### Goulburn River Solar Farm

The Department of Planning and Environment – Crown Lands has reviewed the proposal.

**FIGURE 1.3**  
Design Refinements

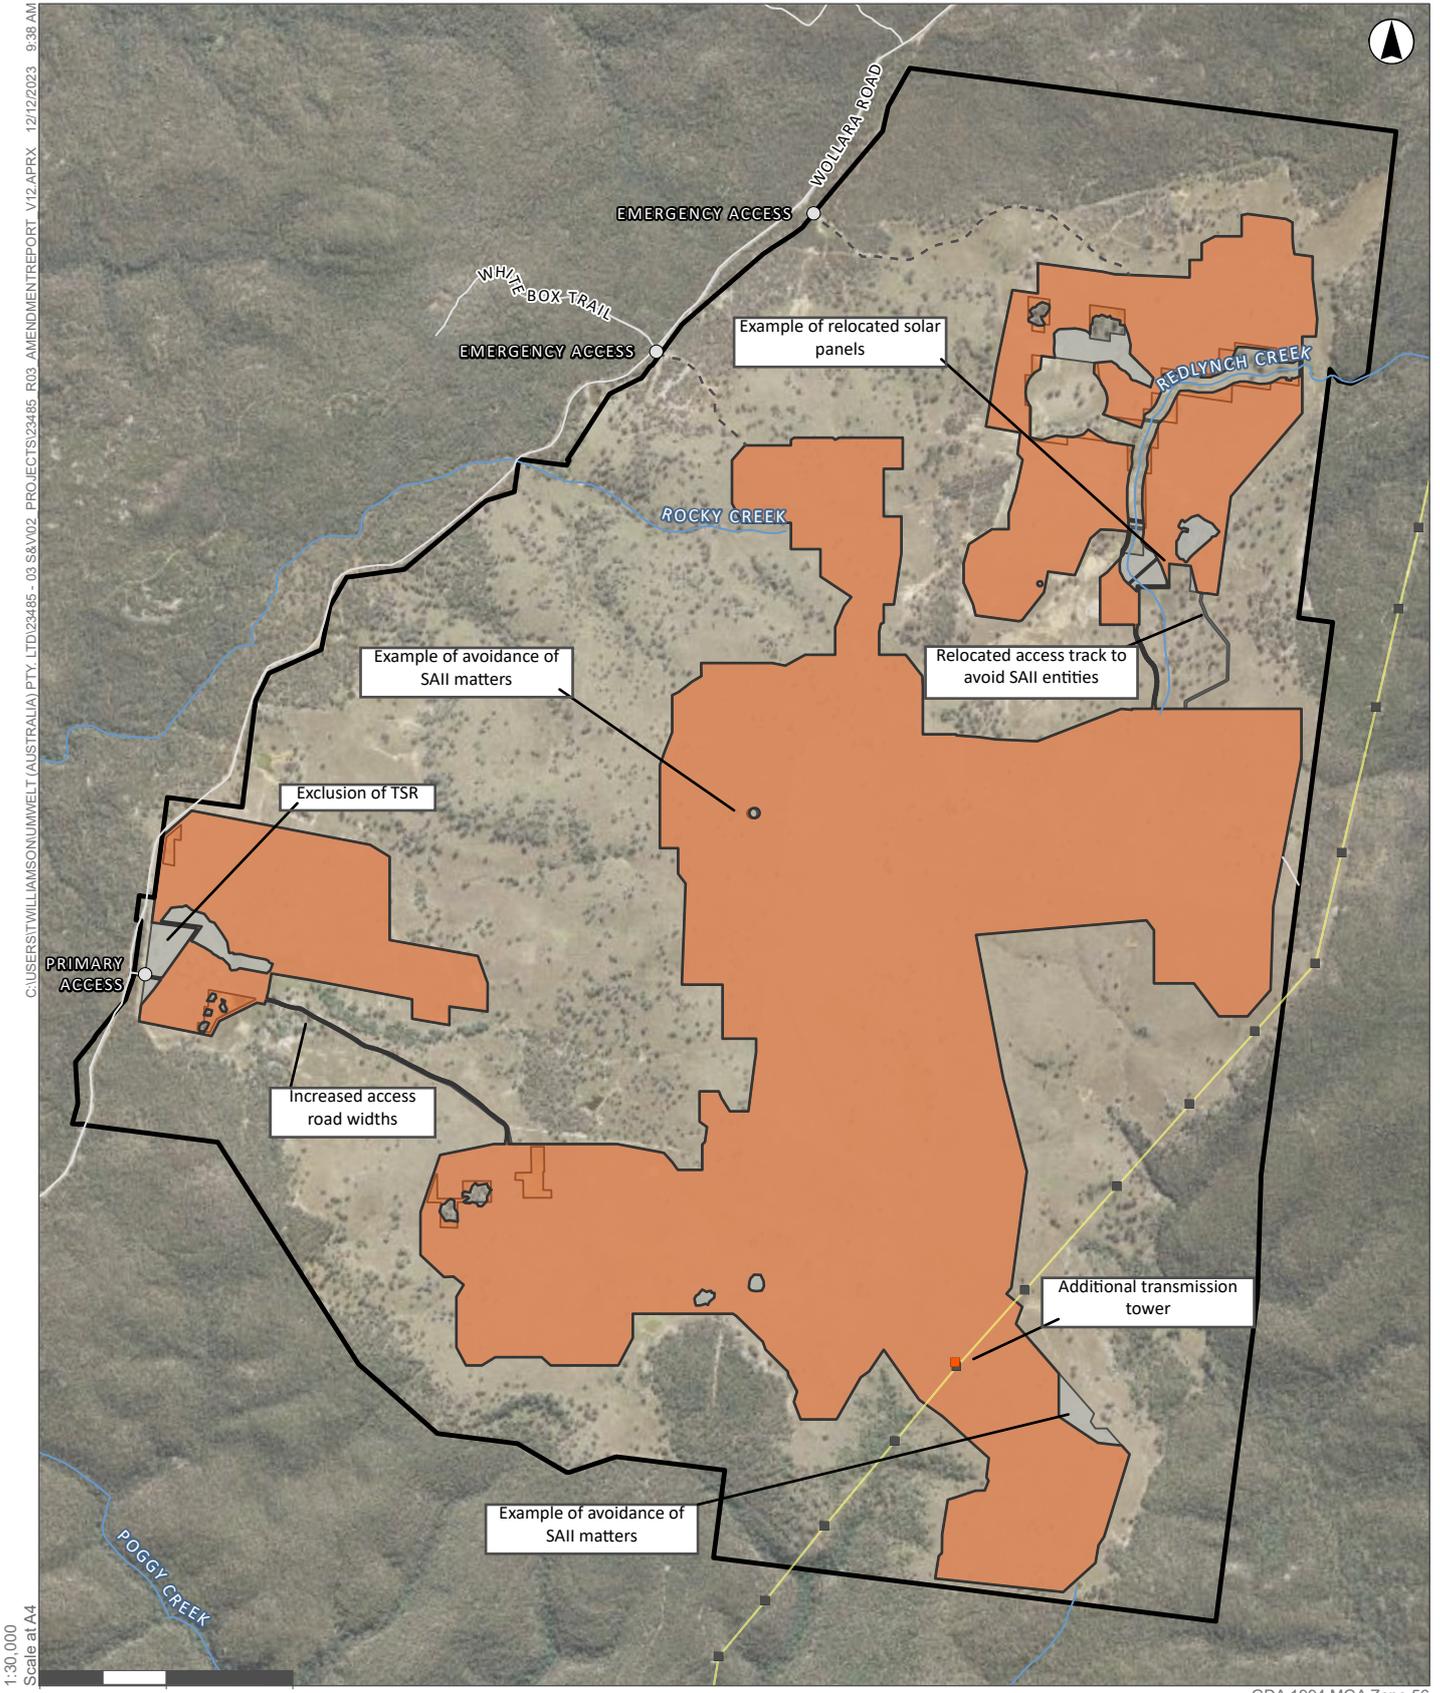
Table 4.1 states “the Project intends to exercise its rights of access over the TSR as an adjoining occupier, in accordance with Section 75 of the *Local Land Services Act 2013*. No infrastructure is proposed to be installed along this TSR”. However, Figure 1.3 shows the proposed access tracks through the TSR as being within the Project Area. Section 6.11.3.3 of the EIS states that “internal access roads consisting of compacted gravel would be constructed... throughout the project area”. Also, the Draft Landscape Plan, shown at Figure 6-16 of the EIS, shows solar arrays and “Planting Area C”, being a proposed dense screen to reduce visual impacts of the solar panels, installed on the TSR. The Conceptual Project Layout shown at Figure 3.1 shows the site Compound Area encroaching onto the TSR.

**FIGURE 3.8**  
Amended Project - Revised Western Extent of the Project Layout to Avoid TSR 44841

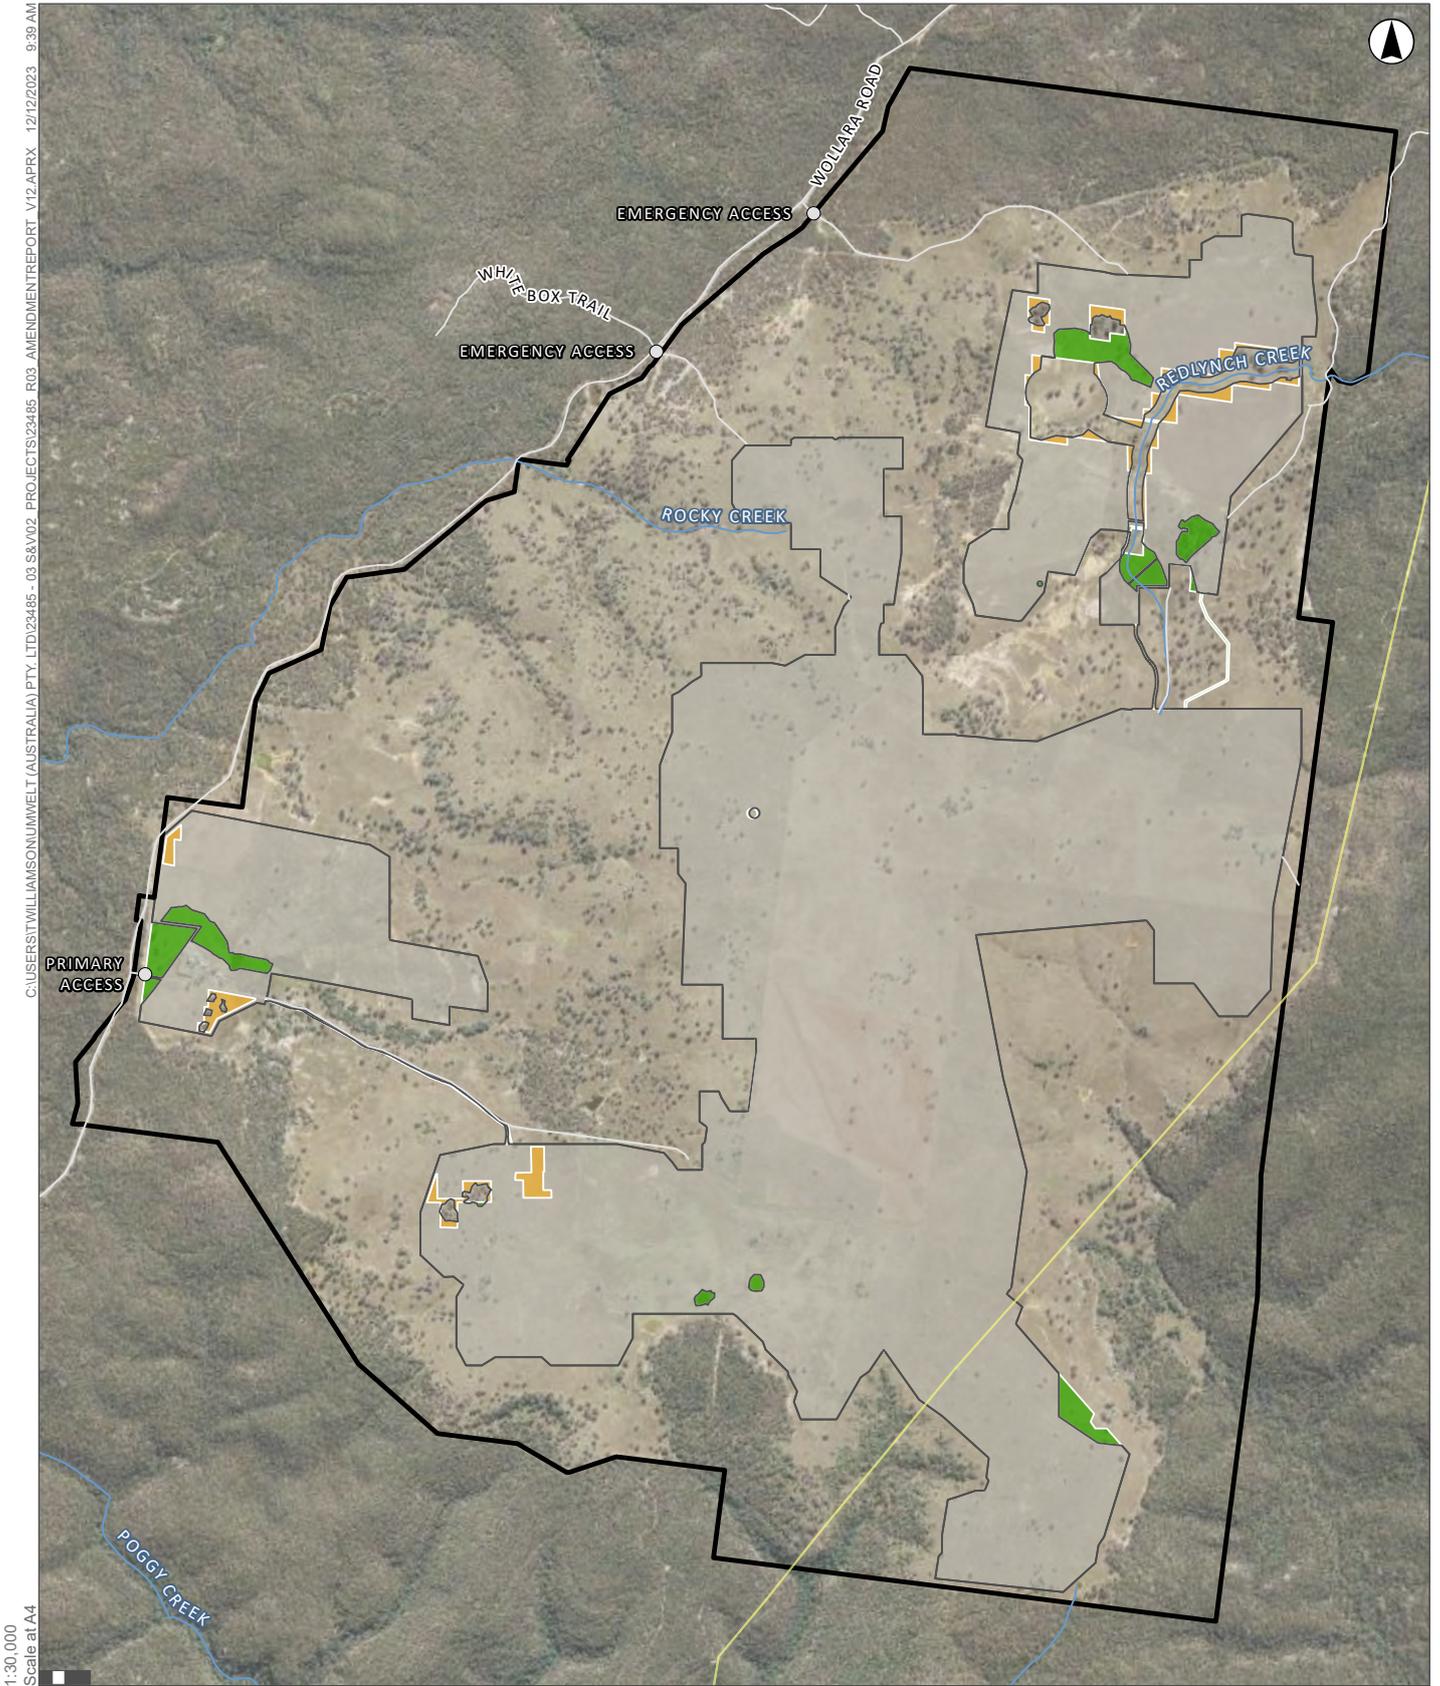
Section 1.7 states that the Proponent intends to “close the TSR within the Project Area” and the Development Footprint shown in Figure 3.1 appears to bisect the TSR. Section 3.3.4 states that “the perimeter of the Development Footprint would be enclosed by security fencing ... approximately 2.3m high... which will restrict public access.” This use is not consistent with the reserve purpose of “travelling stock” nor with the public’s use and enjoyment of the Crown reserve.

Crown reserves are not available to offset the impacts of private development, and Crown Lands does not support revoking the Travelling Stock Reserve or the whole or partial exclusion of other users from the TSR. The Proponent should modify their proposal so that their use of TSR 44841 is limited to non-exclusive purposes that are consistent with the Local Lands Services Act, e.g.,
